Summary of points made at relevant representations

Figure 3: Indicative Beach Working Areas for Trenchless Installation Works

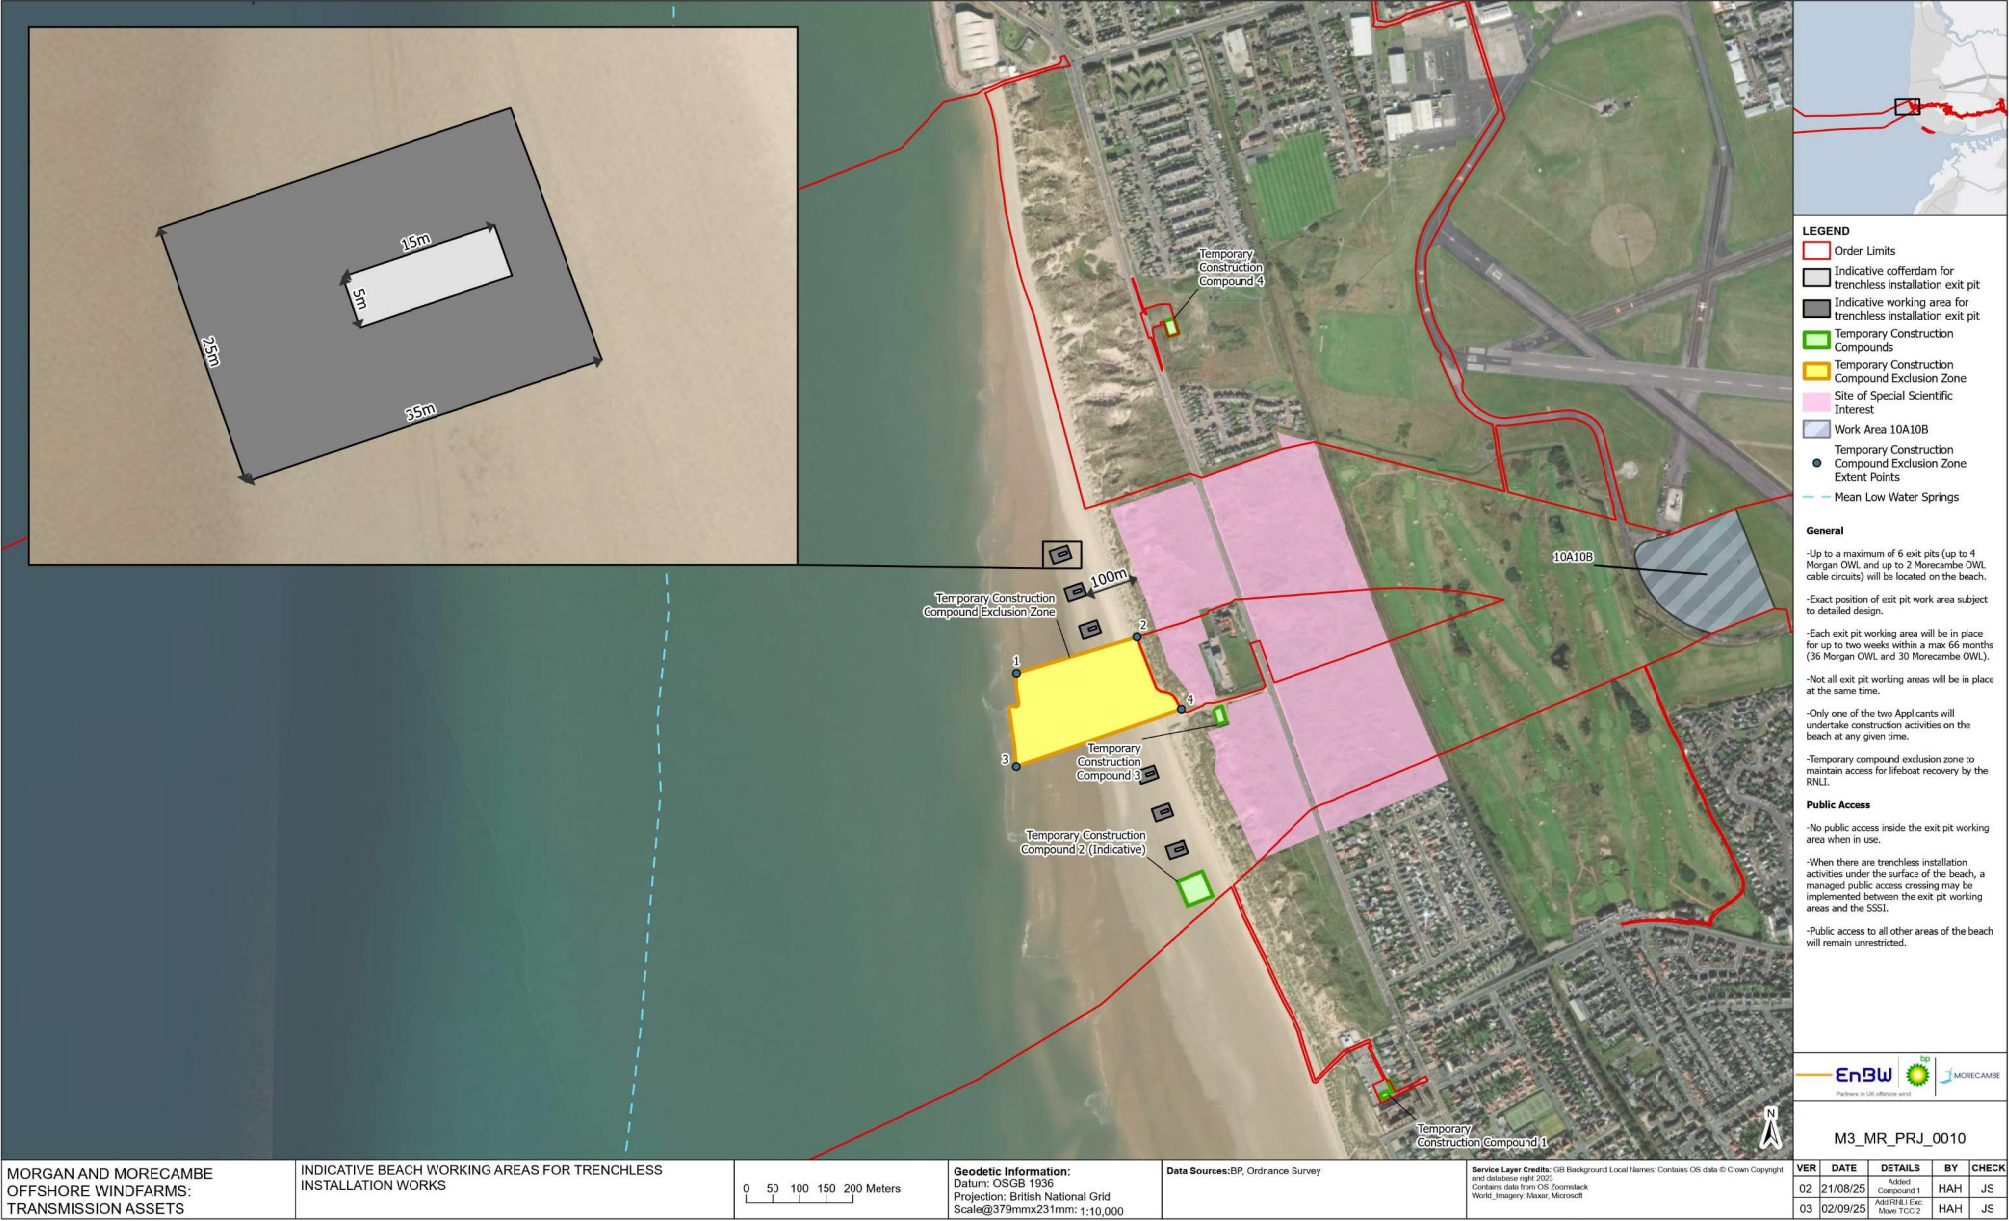
Beach access at St Anne's faces will result in closures without mitigation plans and was dismissed as a concern by the Applicants, whereas it is clear that closures of the beach will occur and there appear to be no mitigation plans for access in place. The Applicants refused to provide plans for the beach when asked by the Inspectors.
